# Falcon Fire Station No. 3 Grading & Erosion Control Plans El Paso County, Colorado

GEC PLAN  
TITLE SHEET

PCD FILE NO. PPR-20-24

SITE GRADING & EROSION
CONTROL PLAN

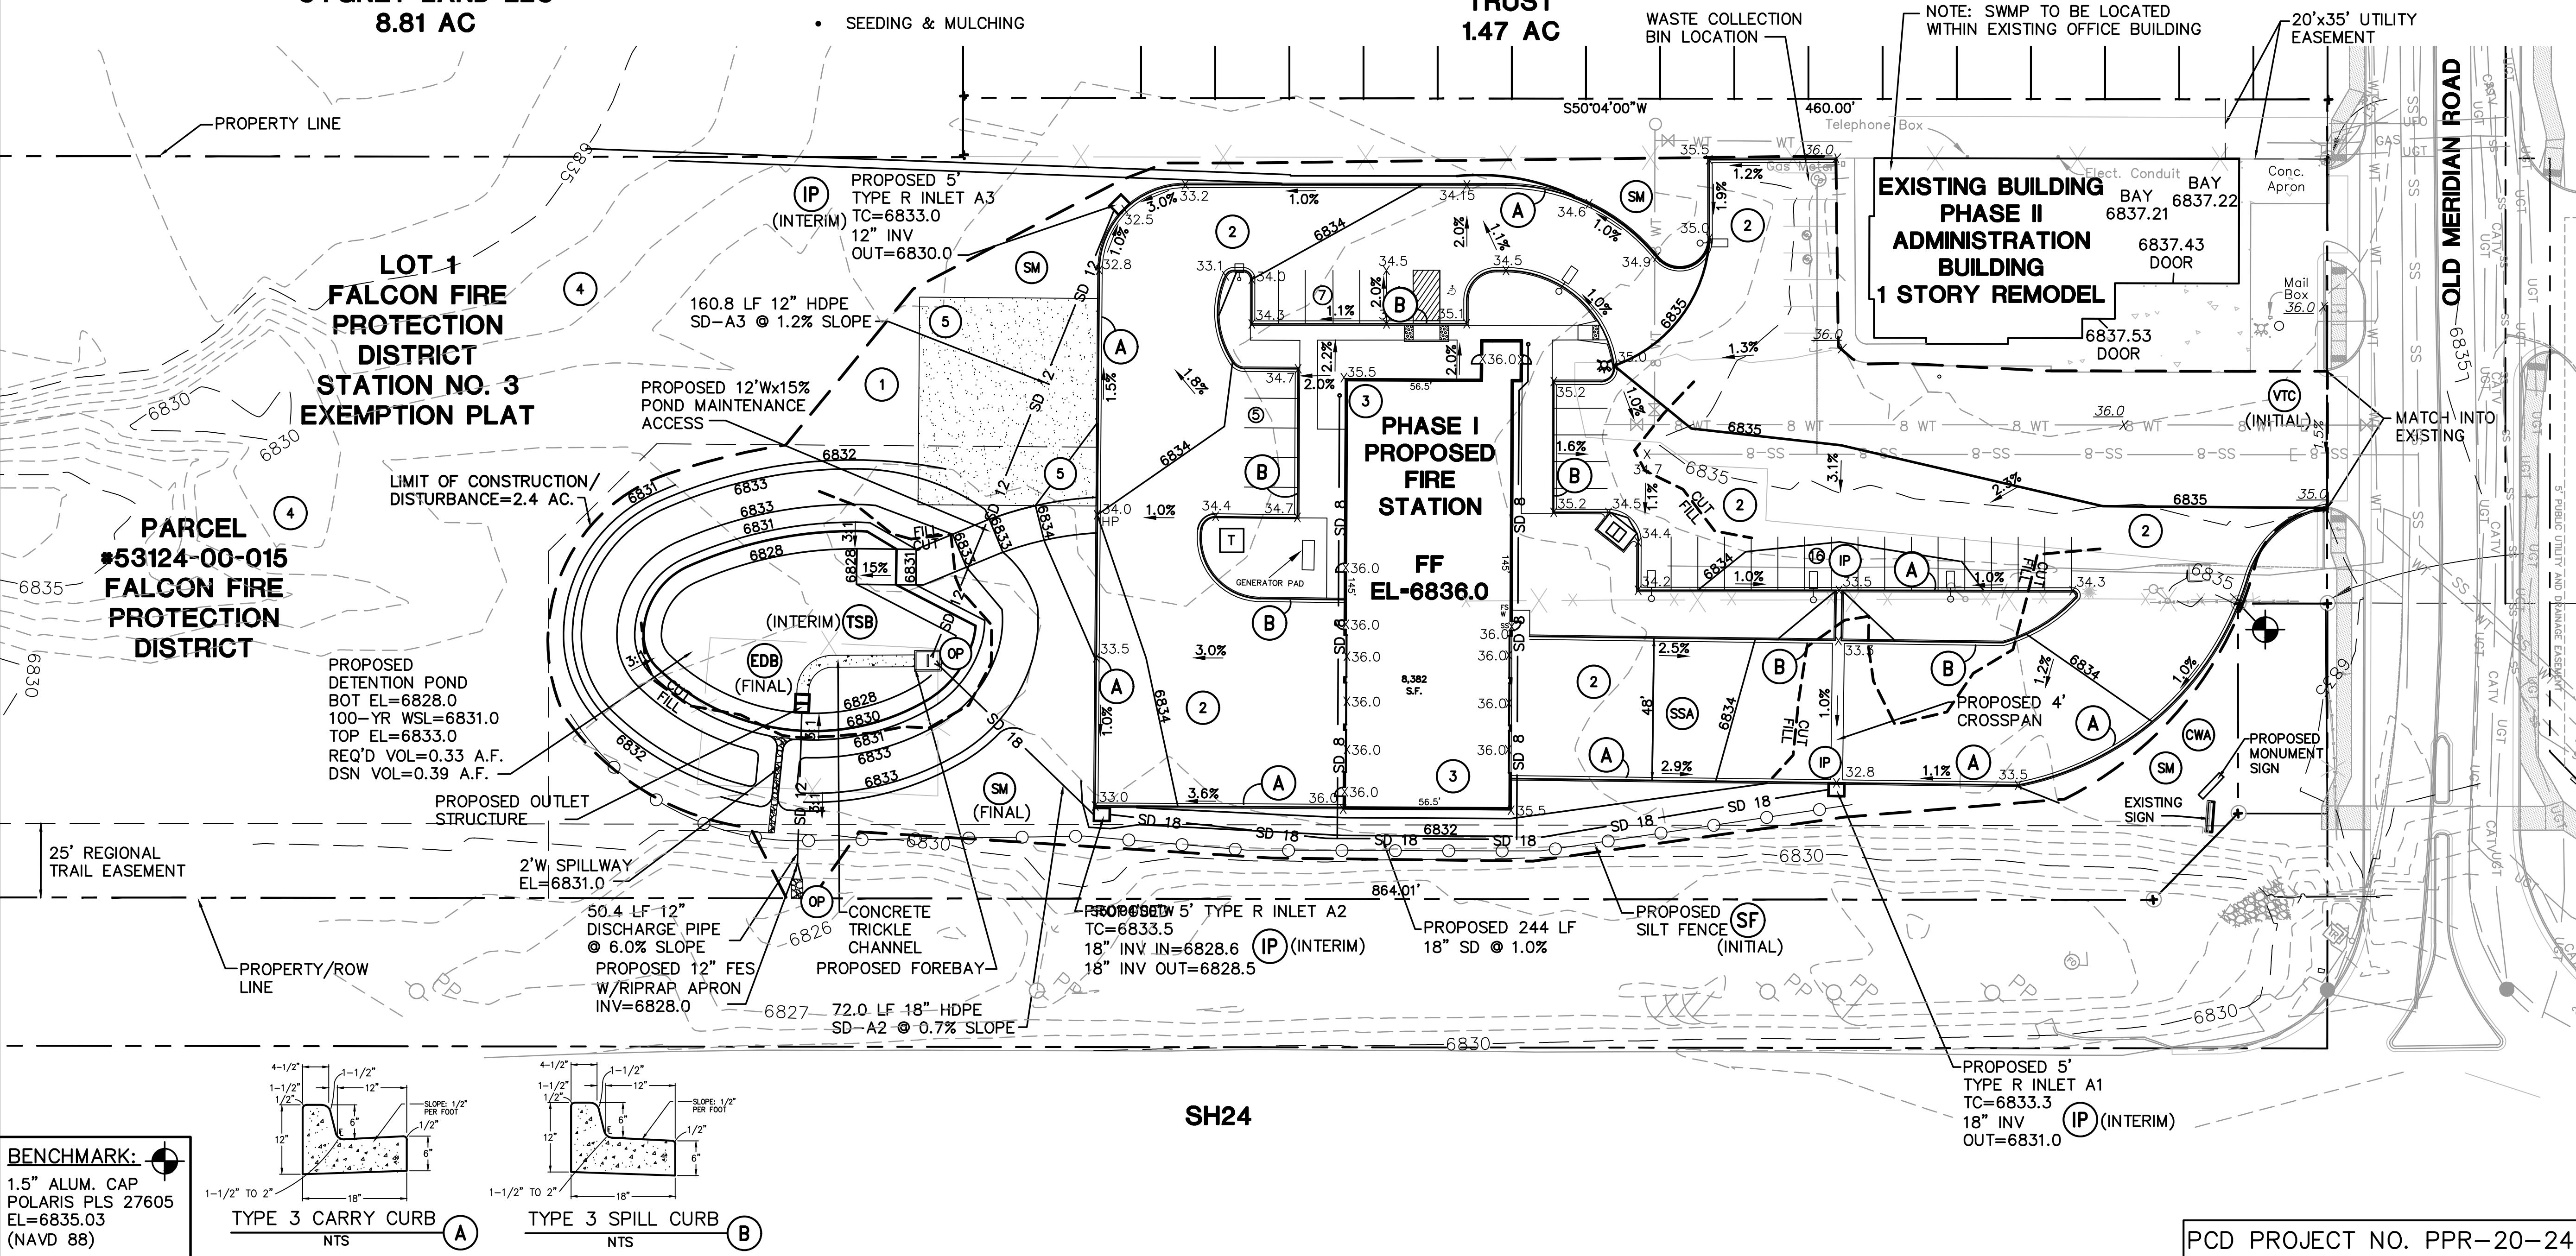
Specify what the temp OP will be. Is the FES to act as temp and permanent OP? Either way, MHFD detail EC-8 may be appropriate to include with plans

ORIFICE PLATE AND TRASH RACK DETAILS AND NOTES (B)

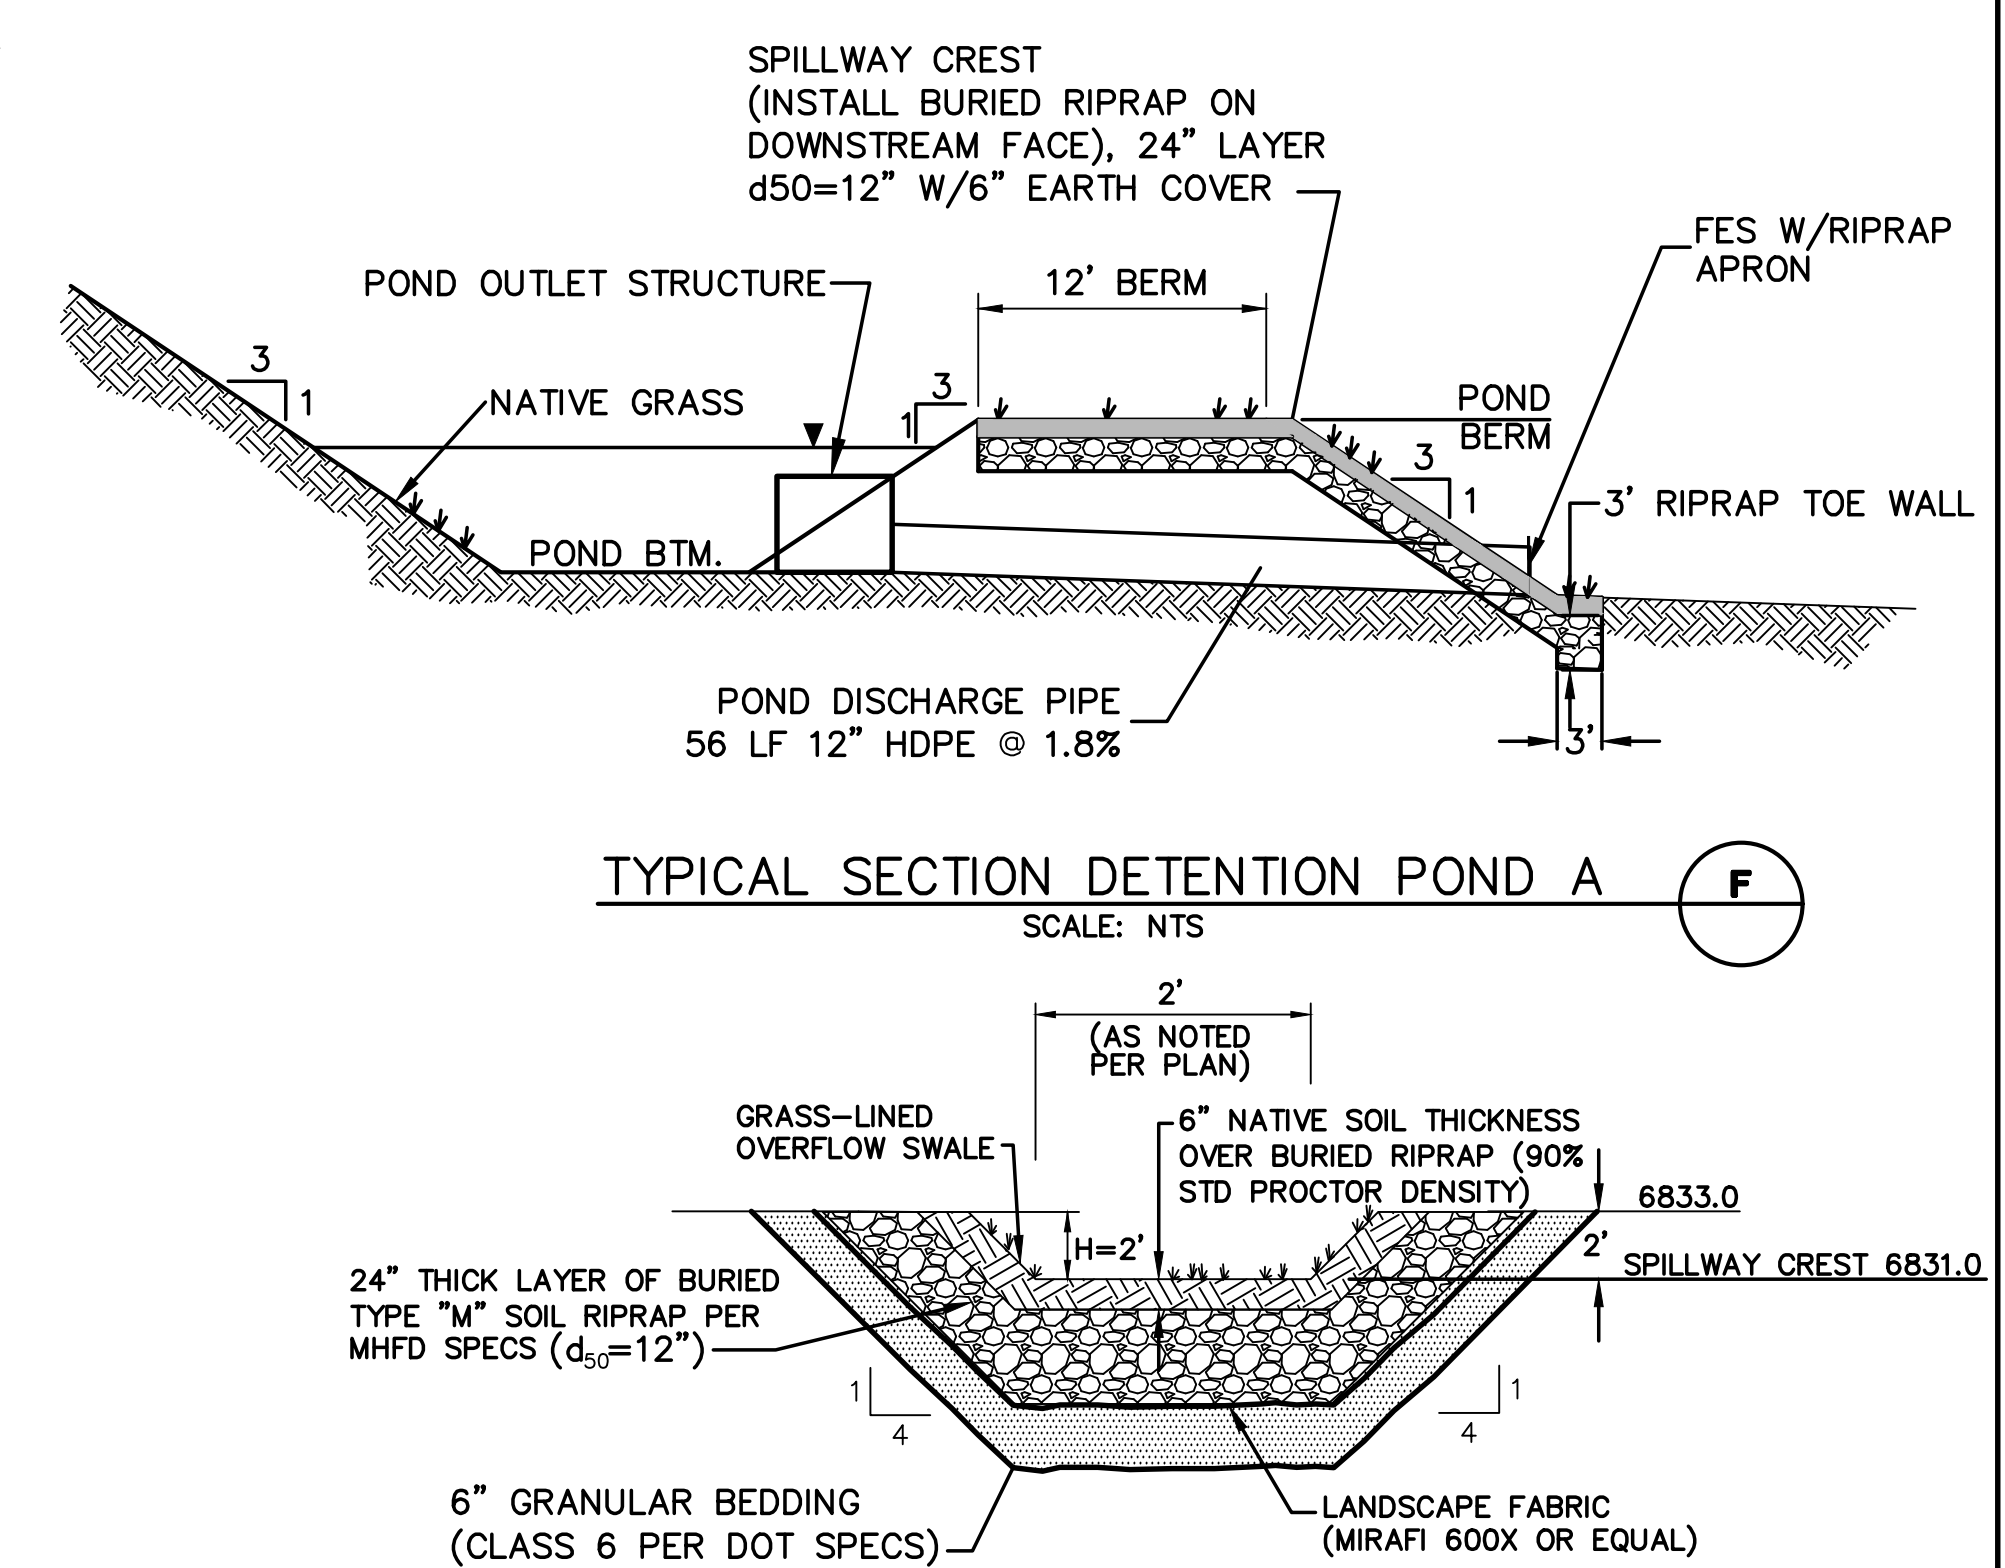
Plan drawing on sheet C1 still says 12W. Revise so they are not contradicting.
